HOME PLANS, INC.

May 2, 2023

Re: Oakdale plan (200116B)

FIRST FLOOR STRUCTURAL
Oakdale

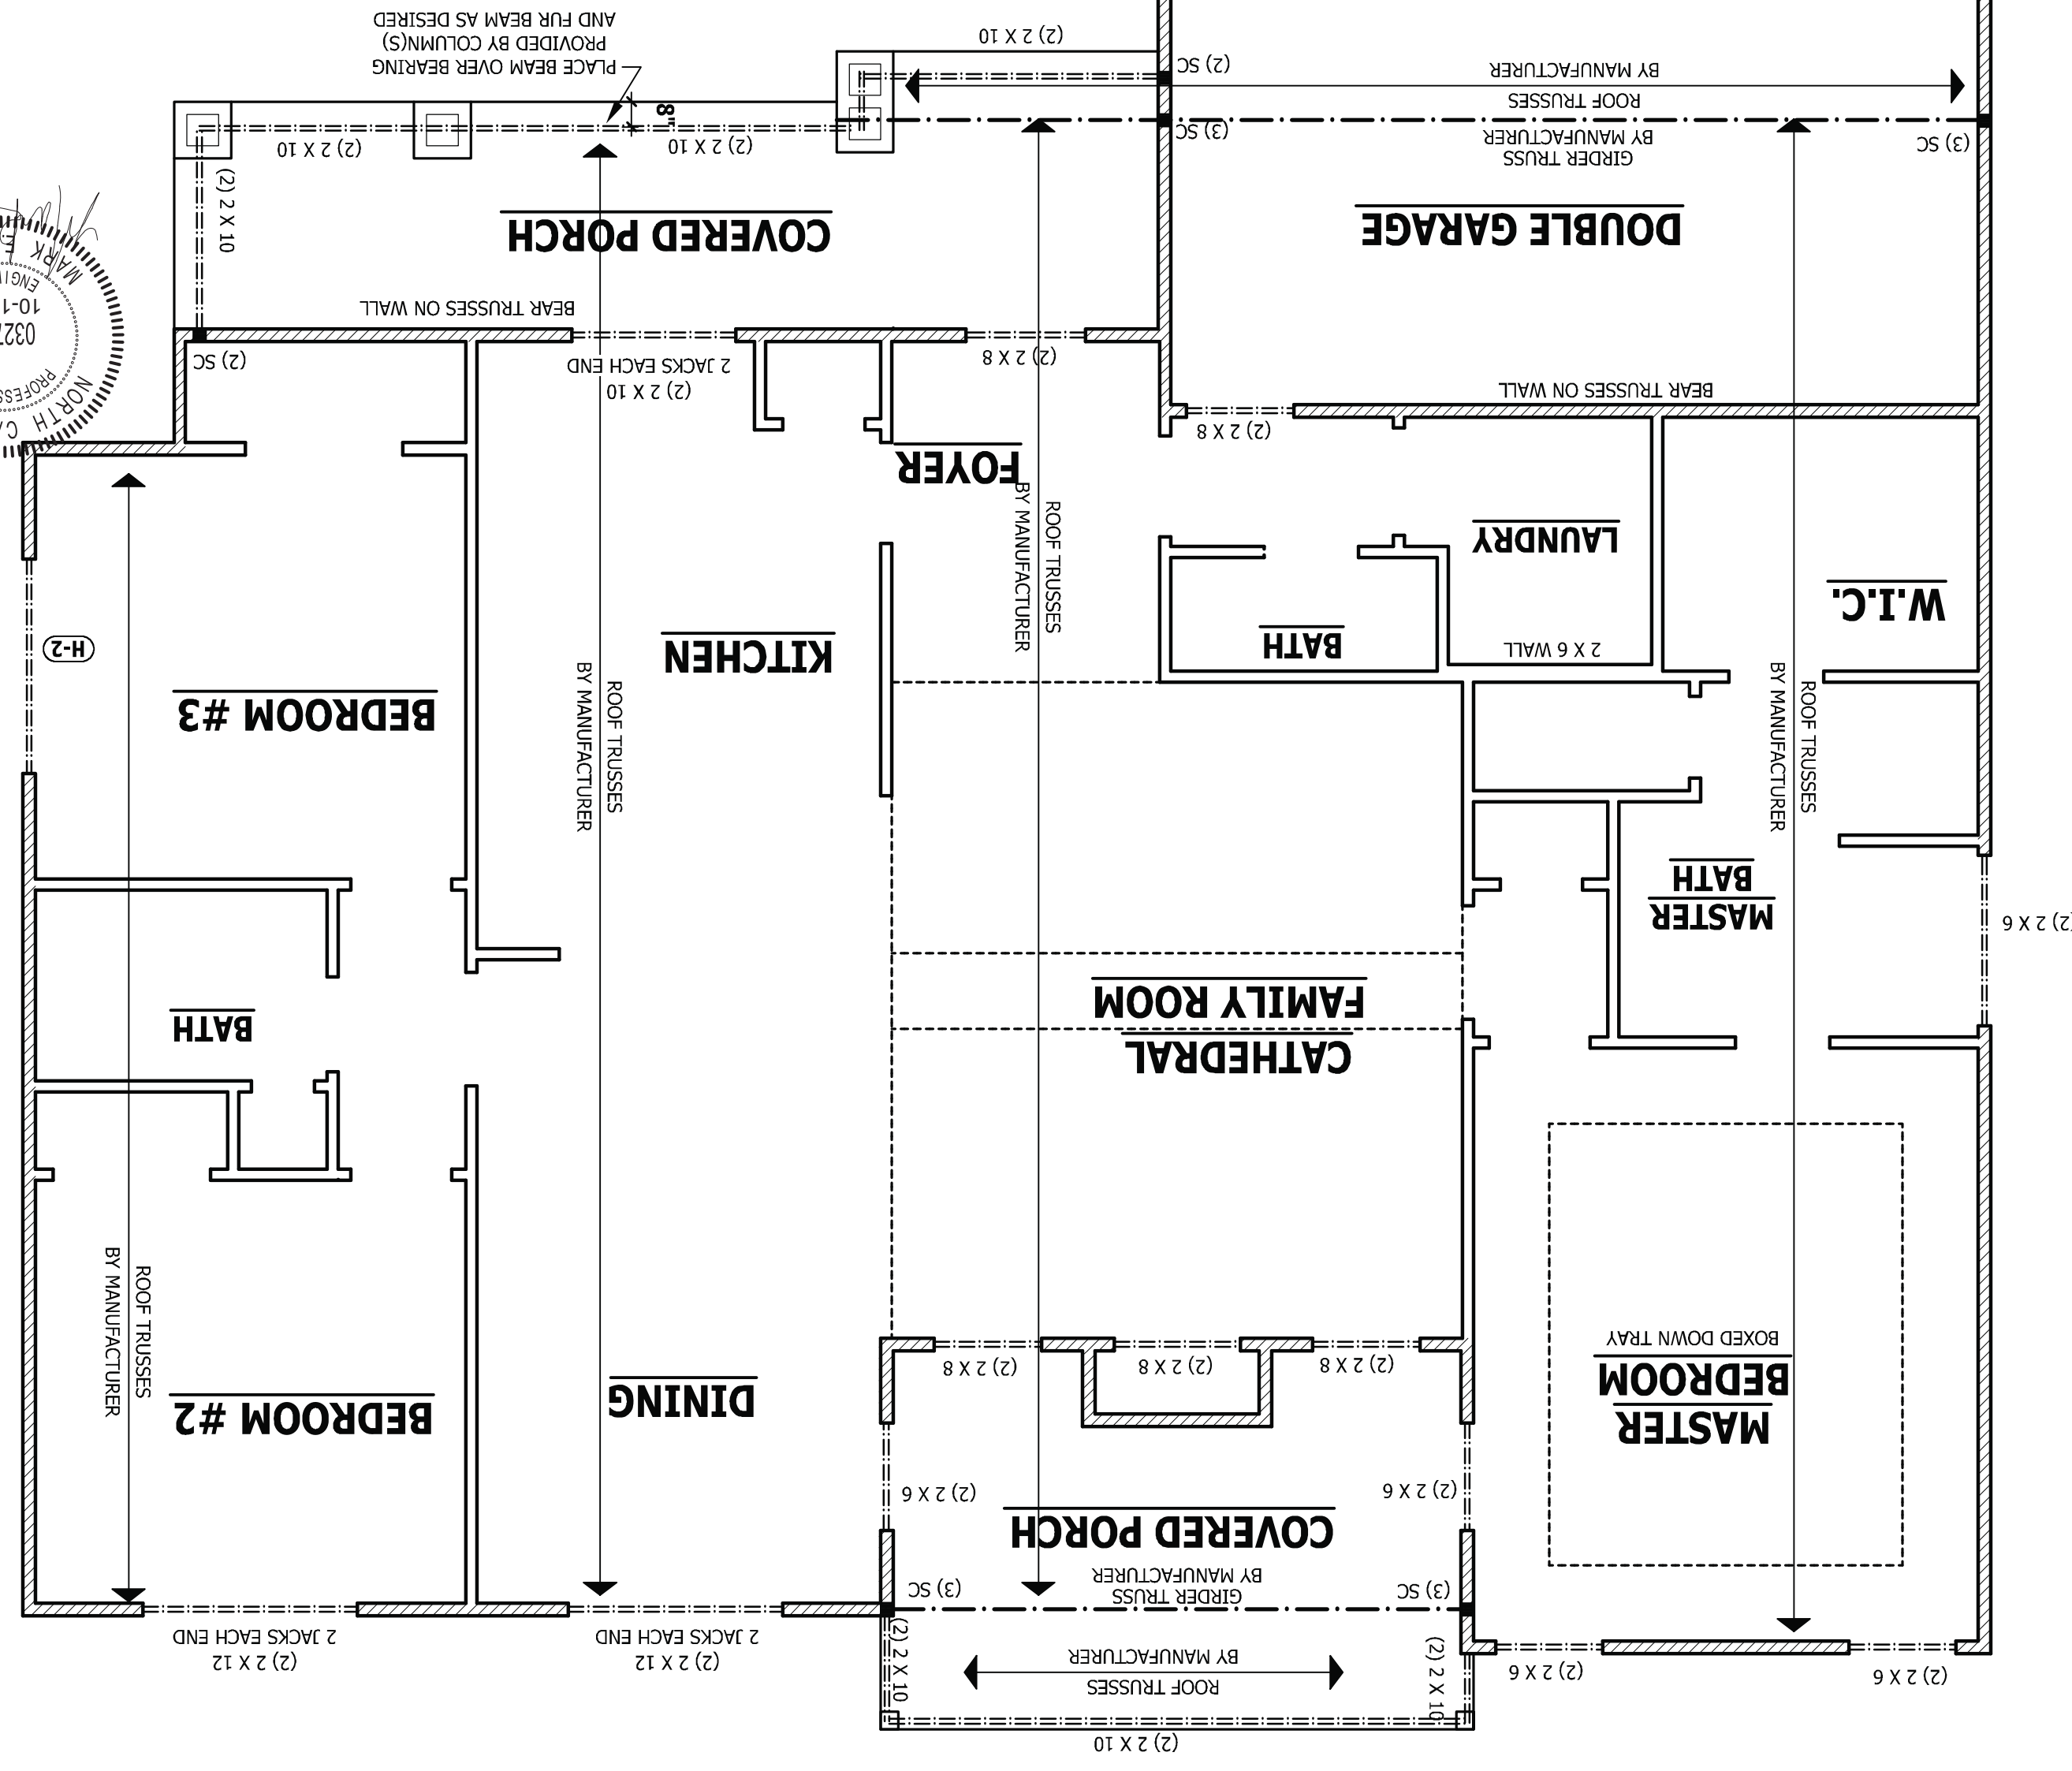
Per our conversation about the Oakdale plan and the H-2 notation at the side window in Bedroom 3 that is our old notation referring to a (2) 2 x 6 header. That was left on the plan by mistake when the plan was updated. Please ignore that notation and refer to the "Exterior Headers" chart on that page. The correct header for that window should be (2) 2 x 6.
